13/11/2020

**Moorebank Intermodal Precinct West - Concept & Stage 1, Modification 2
(SSD-5066-Mod-2)
Request for Additional Information**

I refer to the Department's assessment for the Moorebank Intermodal Precinct West - Concept & Stage 1, Modification 2 application (SSD-5066-Mod-2). After careful consideration, the Department is requesting that you provide additional information to progress its visual impact assessment for the proposed modification.

Figure 16 Viewpoint Locations utilised by Roberts Day to Inform the Preparation of the Visual Assessment concerning the 'JN' Site (Source: Roberts Day, 2020)

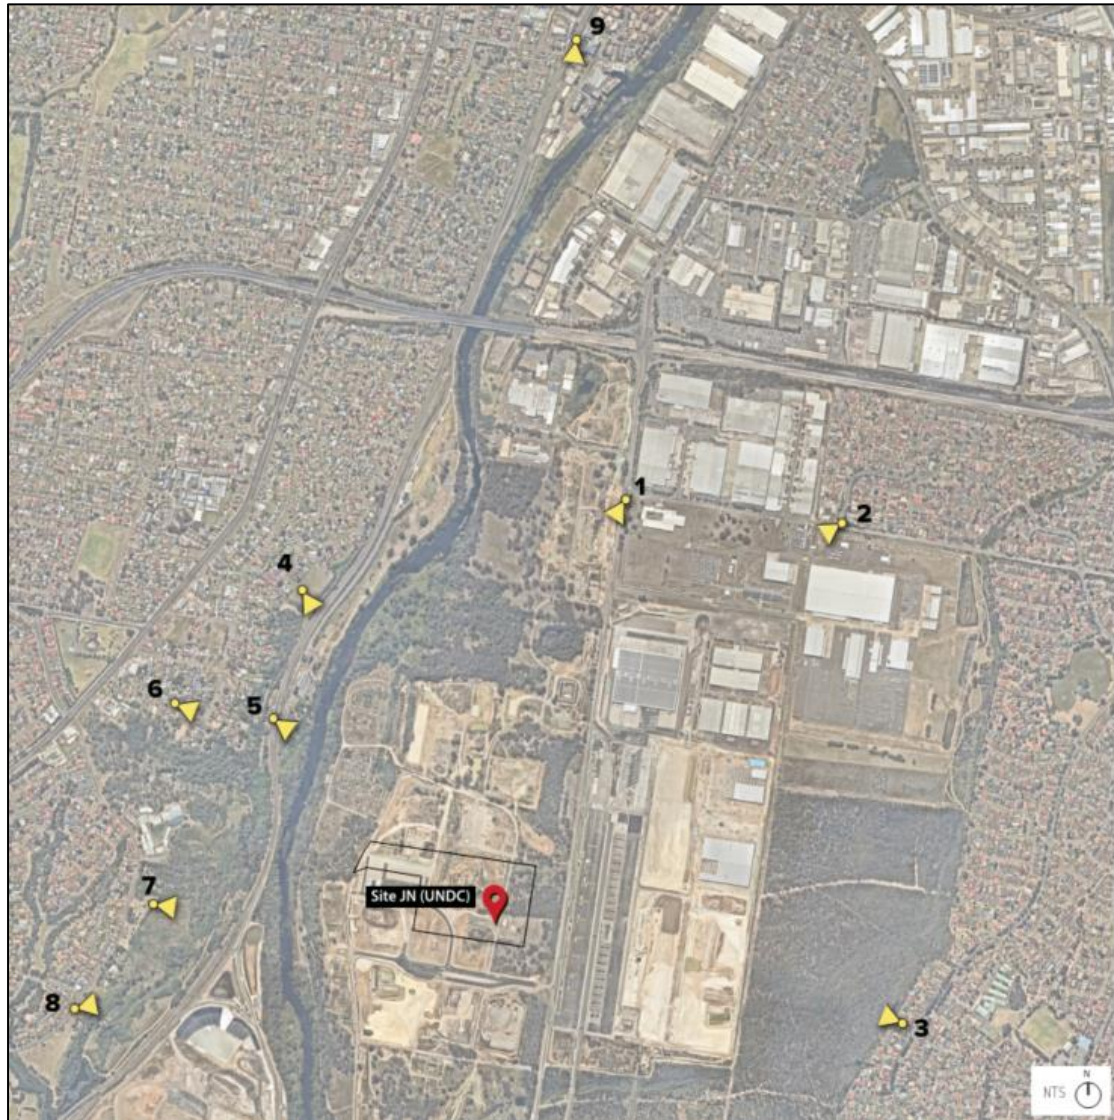
The Department notes that there is an error contained within the visual assessment reports for the warehouses JN + JR dated October 2020, relating to the private view shown at View Point 9 (attributed to 7 Casula Road). Rather, the survey appears to have been taken from the mid-way point of the sloped driveway at 3 Casula Road, below the private residence which is located on elevated land higher upon the ridge. The sightline therefore does not provide an accurate representation of the visual impact of the high-bay warehousing from the elevated properties at Casula Road, many of which appear to have unobstructed views over the MPW site.

1. additional visual impact surveys, to be taken from private vantage points at the worst affected elevated residences at Casula Road (i.e. from the residence itself);
2. amendments to remove the erroneous reference to 7 Casula Road for View Point 9; and
3. ensure that the reports revisit each of the vantage points used to inform the visual impact analysis for the approved Stage 2 application.
